1.1.1 Velocity Transport Planning (VTP) has been appointed by Firethorn Trust (the Applicant) to provide highways and transport planning advice for an outline planning application relating to the development of up to 530 dwellings on land which forms part of the North West Bicester Eco Town development, located in Oxfordshire.

1.1.3 The Proposed Firethorn Development description for the outline planning application (planning ref 21/01630/OUT), is as follows:

1.3.1 This TN has been prepared to provide comprehensive responses to those consultees identified above and to provide further clarity and/or additional information that has been identified through the review of these consultation responses and following post-submission meetings.

REVISION DETAILS		
DRAWING NO.		
4600-1100-T-011		
DRAWN	APPROVED	DATE
EP	MP	JAN 21
SCALE		REV
AS SHOWN @ A3		F

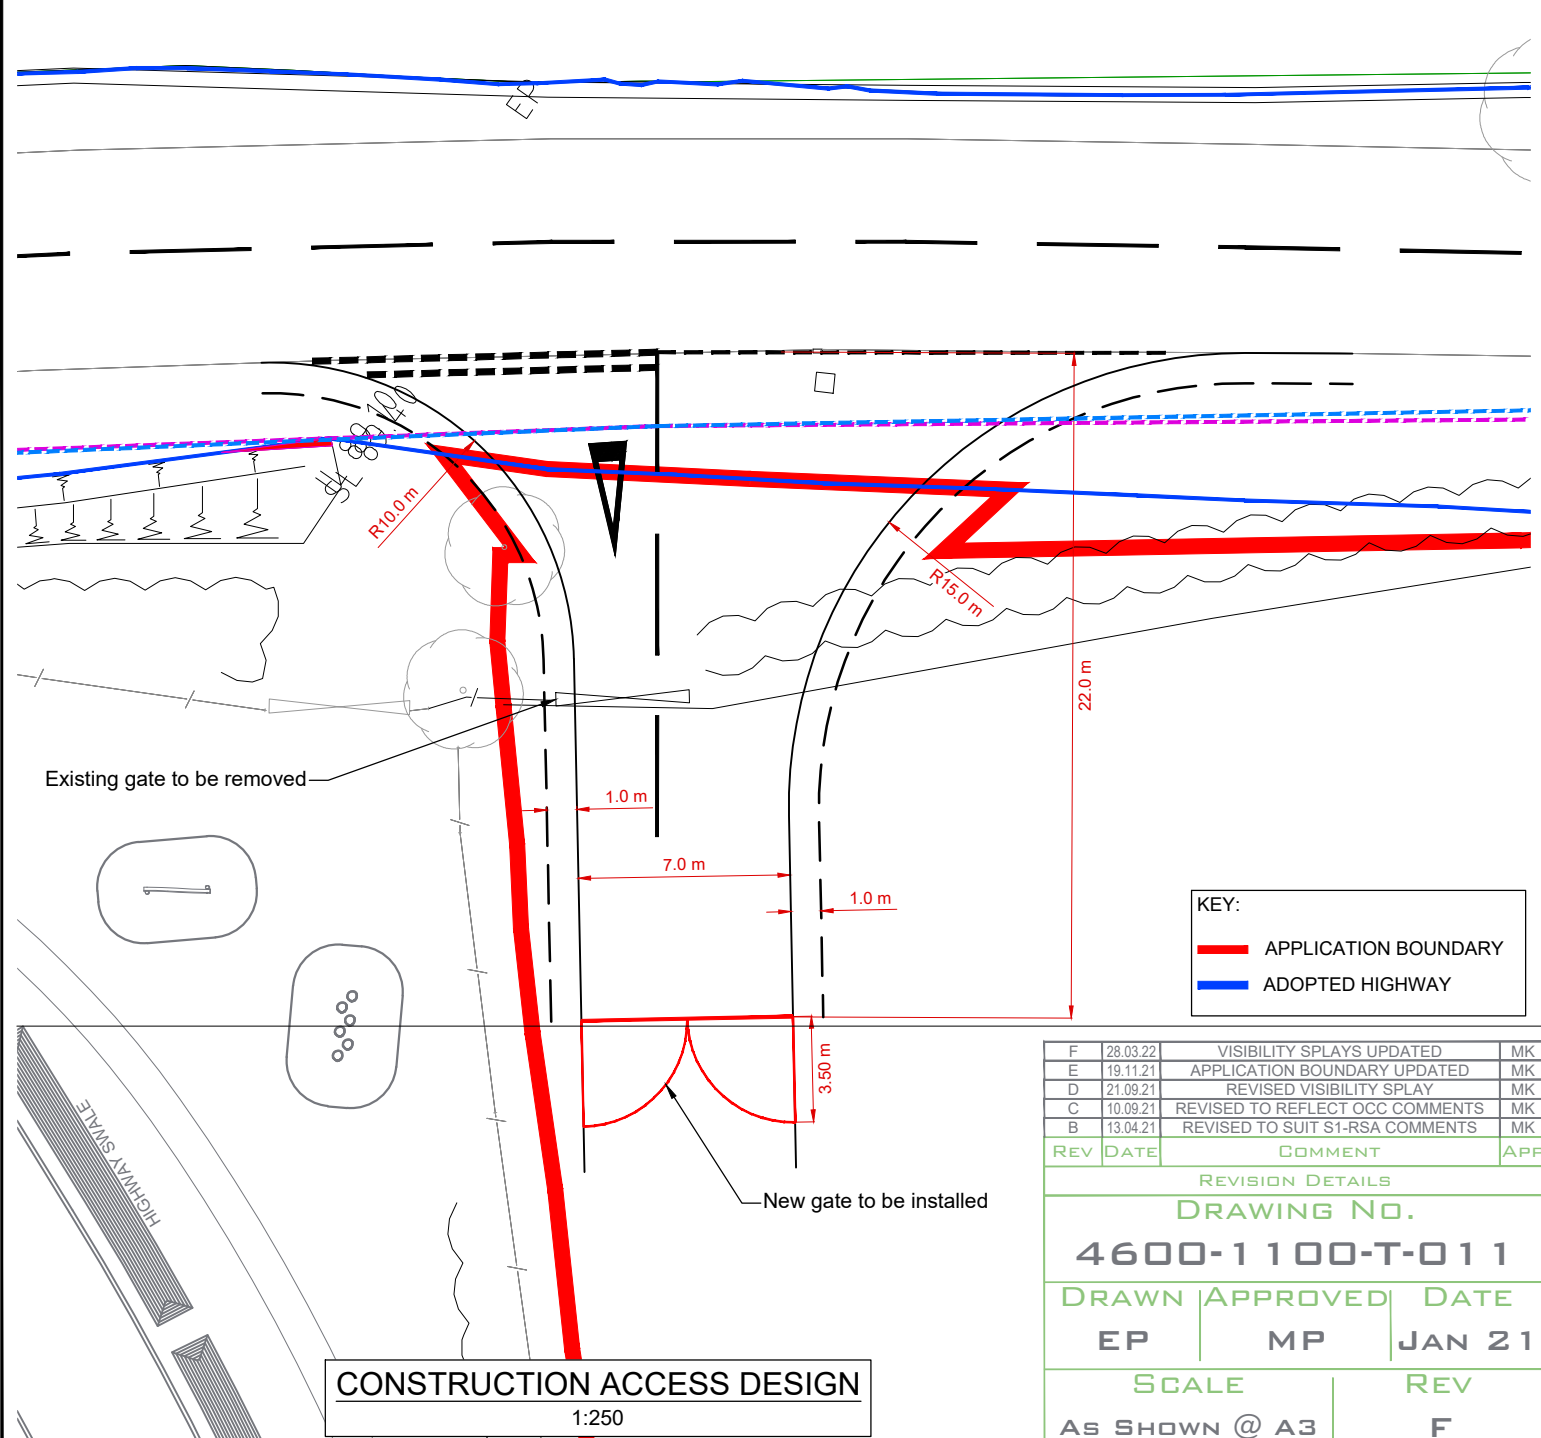
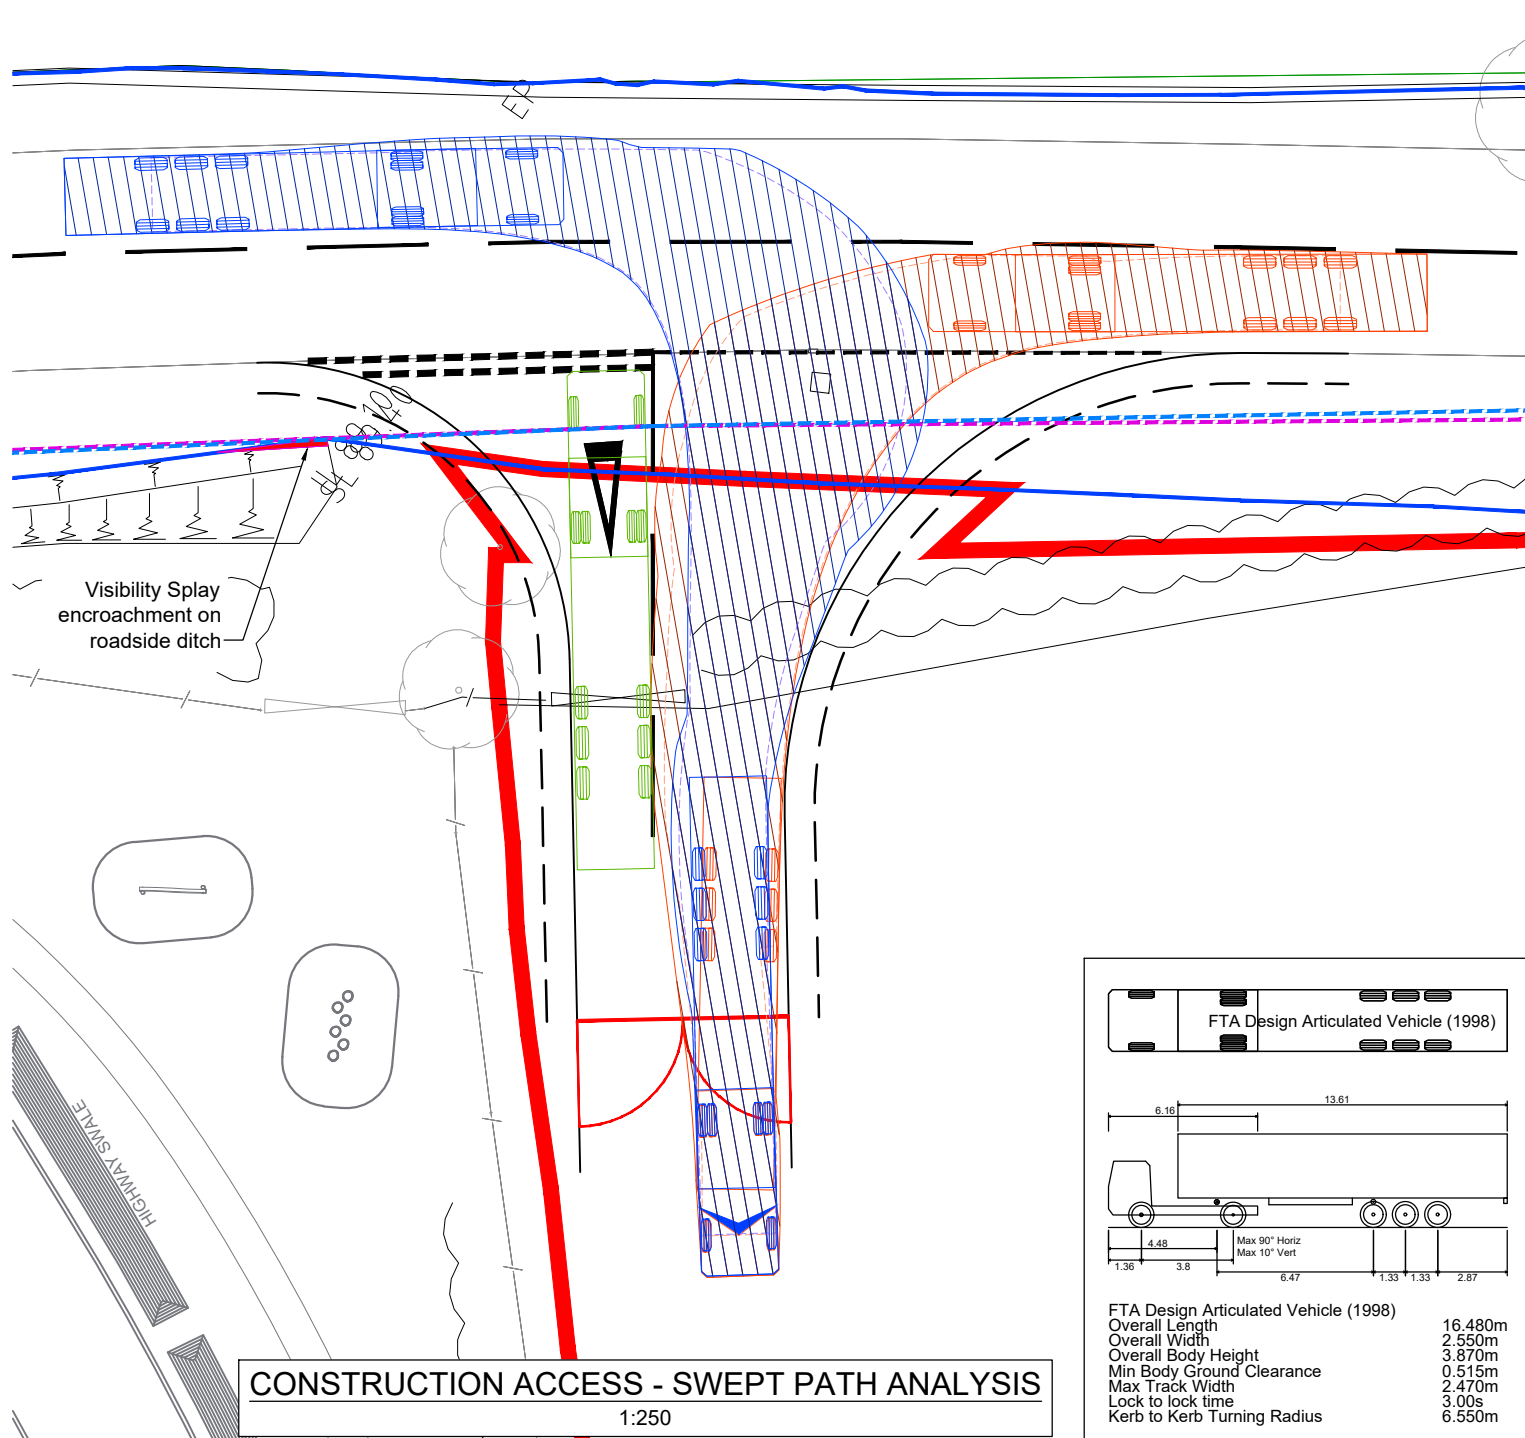
- *Construction Access – details of the extent of adoption are to be checked with the OCC highway records team as it is expected that the ditch adjacent to the B4100 is not adopted. A setback distance of 2.4m was agreed.*
